Submission

SSD-17424905 – 20 Avon Road, Pymble

4 December 2021

Client: Owner of 57A Pymble Avenue, Pymble
Subject land: 20 Avon Road, Pymble
Lot Description: Lot 1, Deposited Plan 69541
Local Government Area: Ku-ring-gai Council
Project Title: Grey House Precinct, Pymble Ladies College
Project Description: The redevelopment of the Grey House Precinct within the grounds of the established College.

4 SHADOW DIAGRAM PROPOSED June 21 - 3PM
1 : 1000

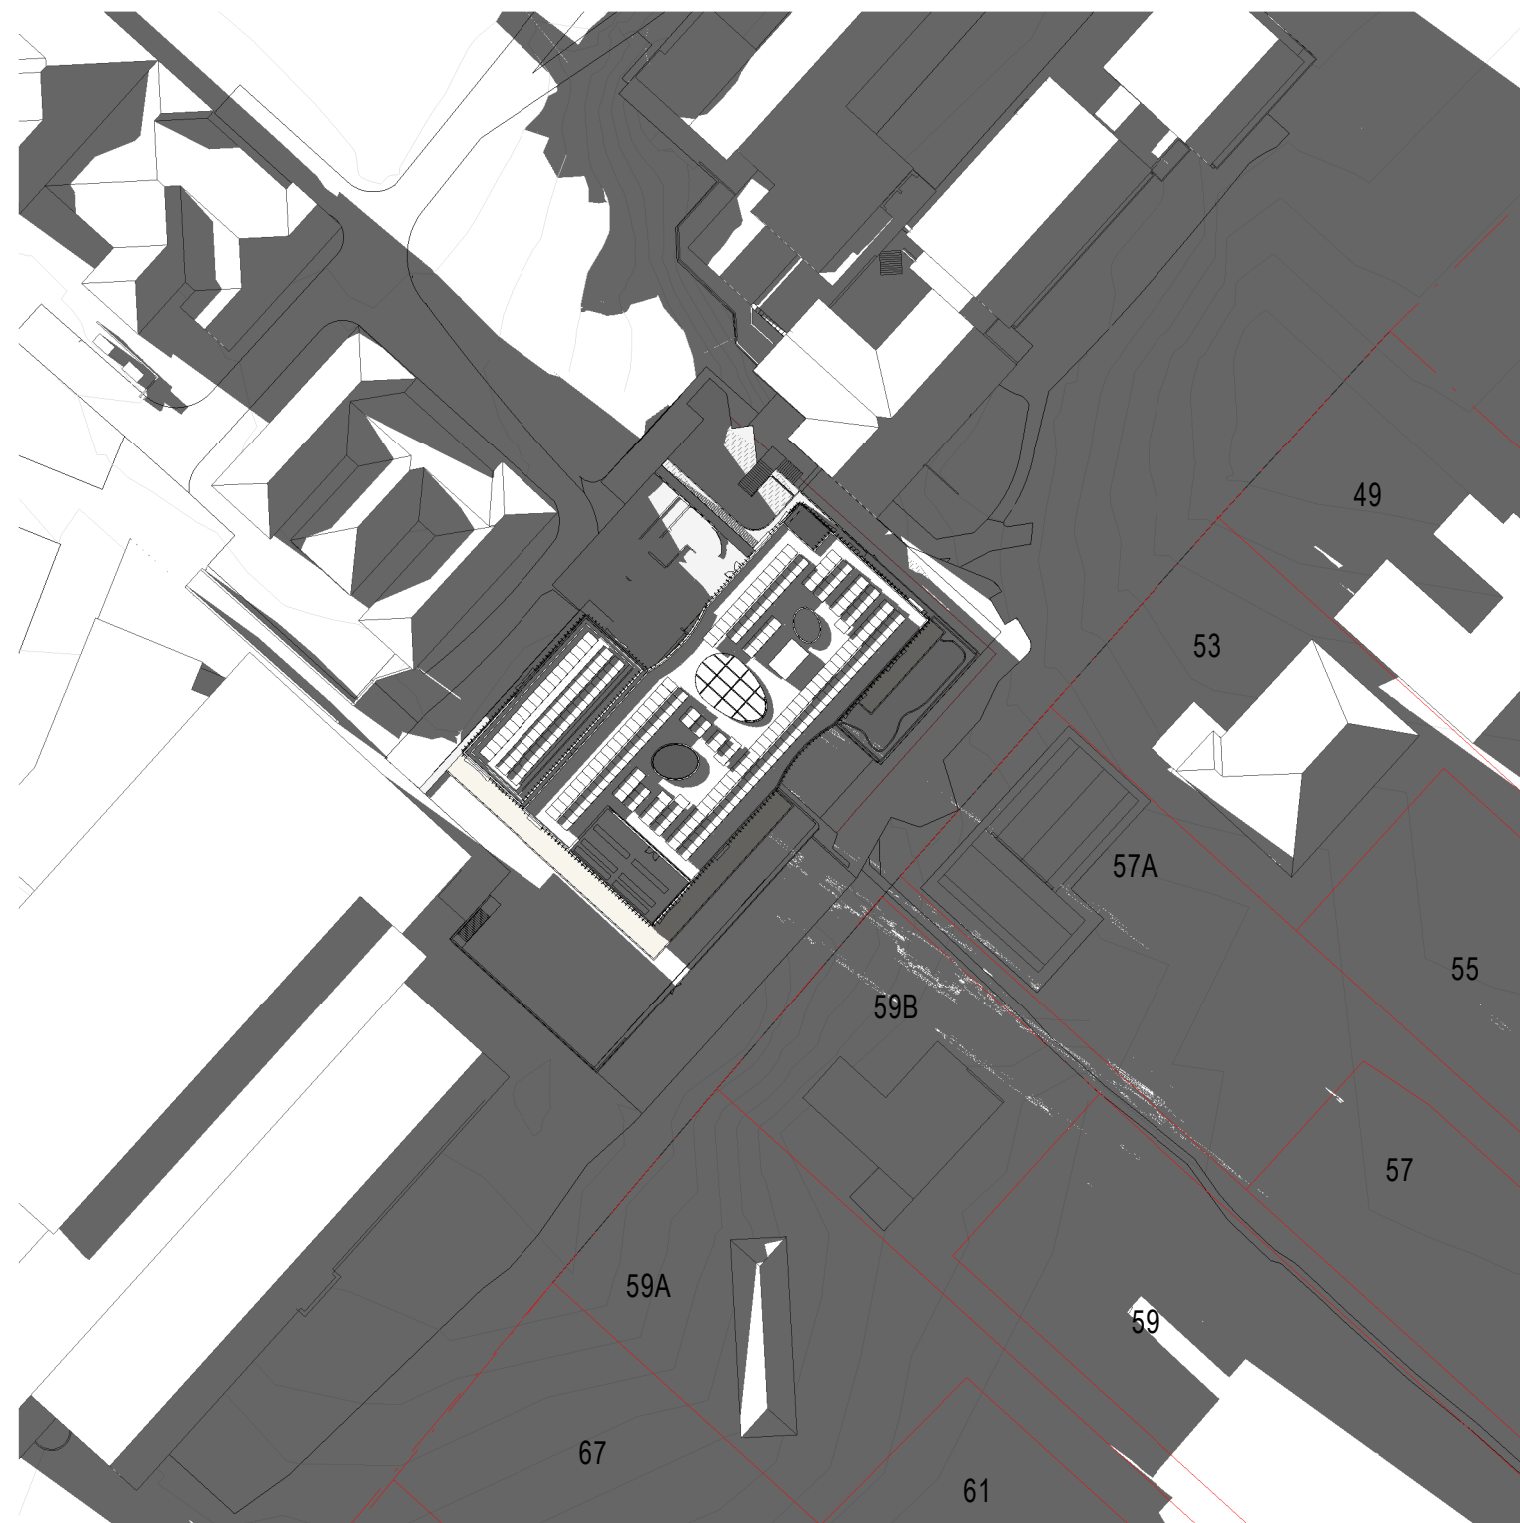
The works proposed under SSD-17424905 will substantially decrease the amount of sunlight received by the PPOS and primary living rooms of 57A Pymble Avenue from midday onwards. As per the proposed shadow diagrams shown in figures 3 and 4, there is severe overshadowing by the

Grey House building throughout the entire afternoon, caused by the minimal proposed southern setback, substantial scale and bulk, and the sloping terrain which naturally elevates the development site.

The above example is identical to the circumstances imposed by SSD-17424905 on the rear garden and north-facing internal living area of 57A Pymble Avenue, Pymble. As highlighted within the shadow diagrams prepared by BVN Architecture dated September 2021 in figure 4, the proposal will block significant sunlight from midday onwards. **This will have a detrimental impact on the current and future residents, and cannot be supported.**

- e) **Action:** Prepare shadow diagrams considering the maximum mature height and spread of the proposed trees between the Grey House building and 57A Pymble Avenue. Plantings should offer privacy without providing additional shadow for No. 57A.
Outcome: To ensure that privacy mitigation measures (ie. proposed landscape screening) does not sacrifice solar access for 57A Pymble Avenue.

ELEVATION - NORTH & SOUTH

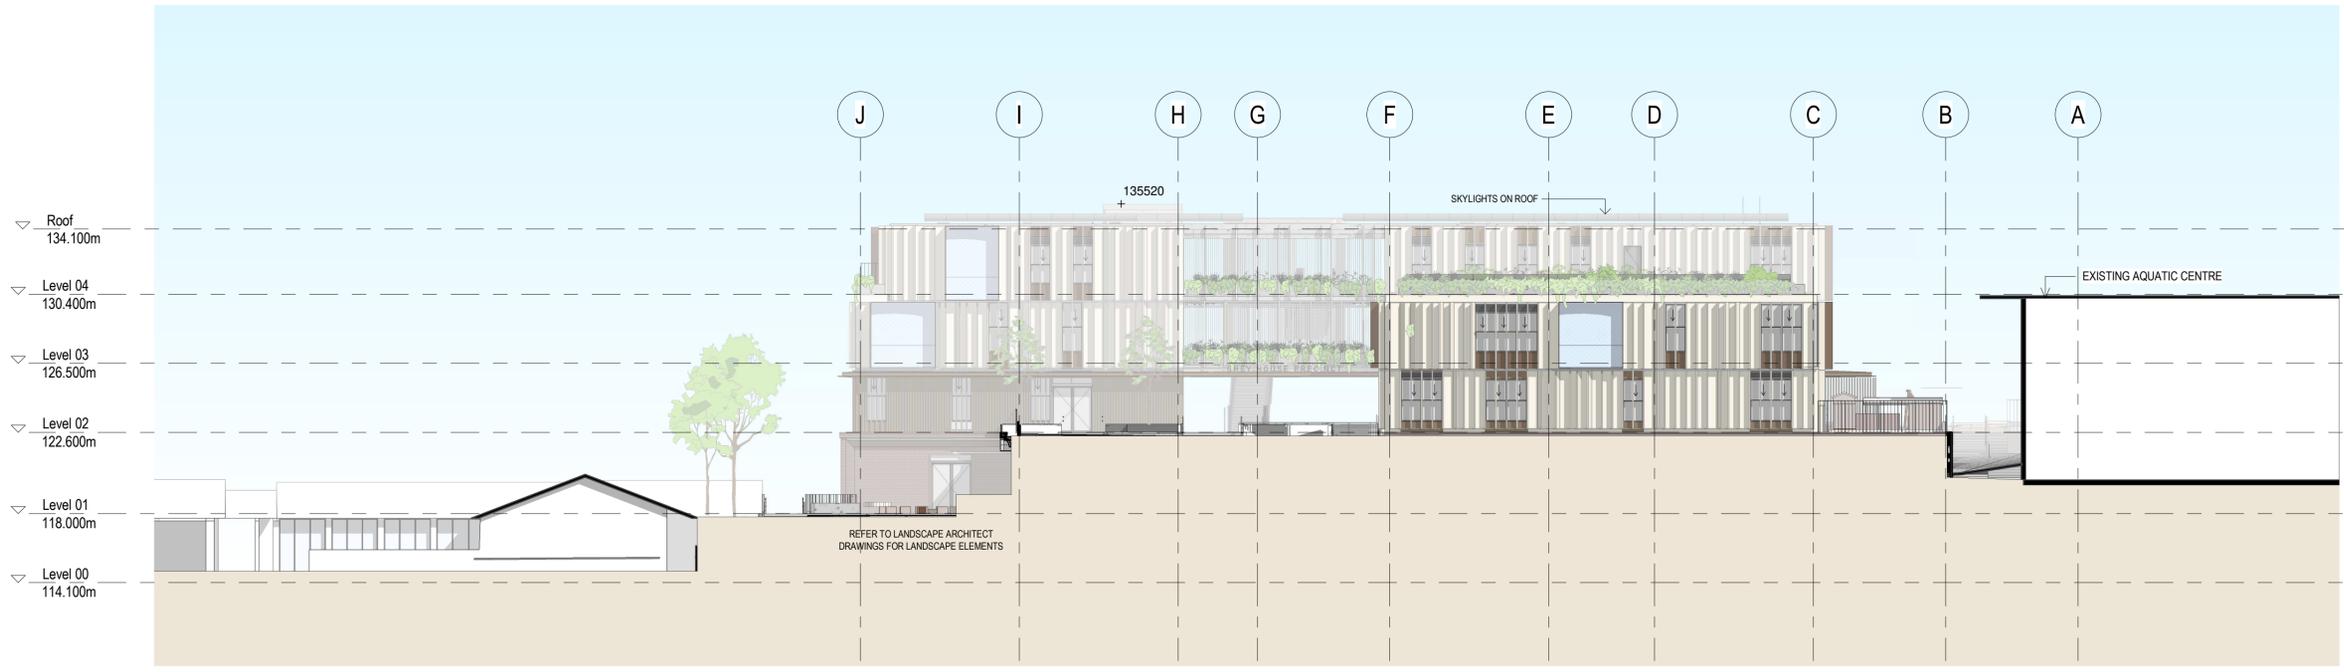
Windows along the southern-eastern elevation of the building proposed under SSD-17424905 are expected to allow for direct views into the principle private open space, and primary habitable living areas of 57A Pymble Avenue, Pymble. Figures 8 and 9 detail these views, straight into the shared living spaces of the single dwelling to the south, resulting in a substantial and unacceptable visual privacy breach. Figure 6 shows the upper floor windows at 57A Pymble which are at risk. The views will be particularly close, given the minimal southern setback proposed (only 12.3m-19.5m).

Large unobstructed glazing panels and the south-facing outdoor learning area on the first floor (“level 01” on the Architectural Drawings) will cause the most issues for 57A Pymble Avenue, as per figure 7.

- c) **Action:** Remove the “level 01” outdoor learning area and make this space non-trafficable.
Outcome: This results in increased visual privacy and acoustic mitigation for 57A Pymble Avenue.

- d) **Action:** Make south-facing large glazing panels on eastern wing frosted, or small windows.
Outcome: This will assist to mitigate privacy issues for 57A Pymble Avenue.
